Submission Form

Epping to Thornleigh Third Track Proposal. Application number SSI 5132.

I/~~we~~ object to the Epping to Thornleigh Third Track Proposal and consider that the EIS is inadequate and does not address the full impact of this proposal. It will cause untold damage to the health of residents and to the fabric of the Beecroft Cheltenham Heritage Conservation Area. Do not approve this project, reconsider the alternatives and protect the community.

Figure 5.6 Cross-section and elevation - New Cheltenham Station concourse building
Note: Indicatively added to future design

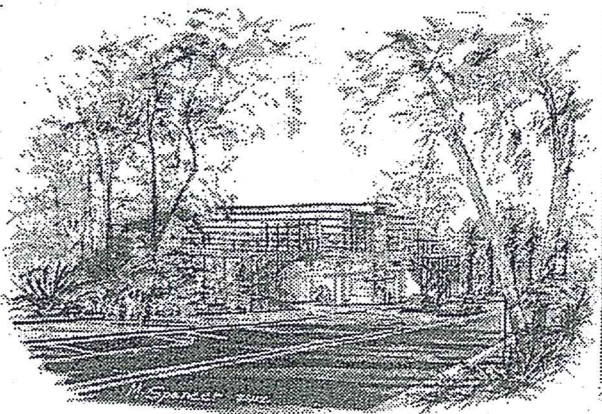
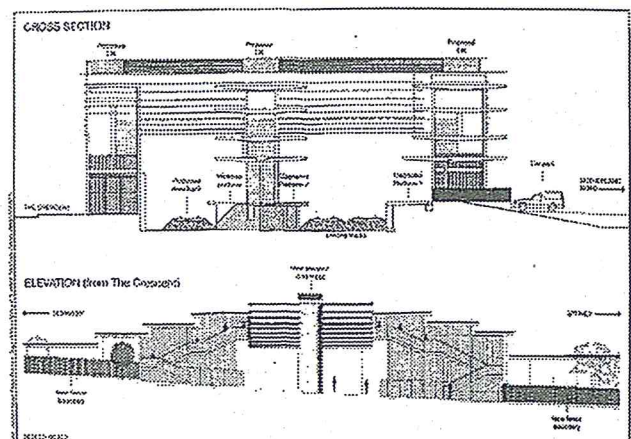
- The proposed redevelopment of Cheltenham Station shows no regard for the HCA. The visual impact of the proposed 13m high glass and steel concourse is totally unacceptable in this HCA.

Concept design drawing of proposed changes to Beecroft Station (Parsons Brinckerhoff 9/3/12). Former side platform shaded in pink.

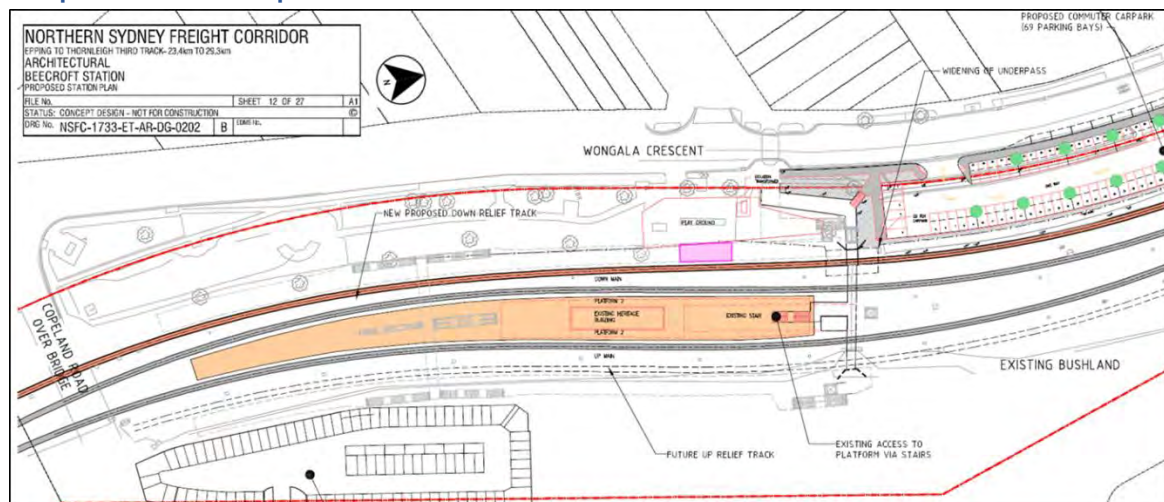
- There has been inadequate assessment of the project's impact on the fabric of the Beecroft Cheltenham Heritage Conservation Area (HCA).
- The plan given for Beecroft Railway station Precinct is vague. The relationship to the trees, playground and original 1895 platform located south of the present station is not shown. A fourth track is shown on the eastern side. The plan does not include urgently needed lifts to allow disabled access at Beecroft Station.

- Beecroft Station Gardens have a heritage listing with Hornsby Council but the impact on them has not been adequately addressed. No arborist's report is given for the trees which will be removed.
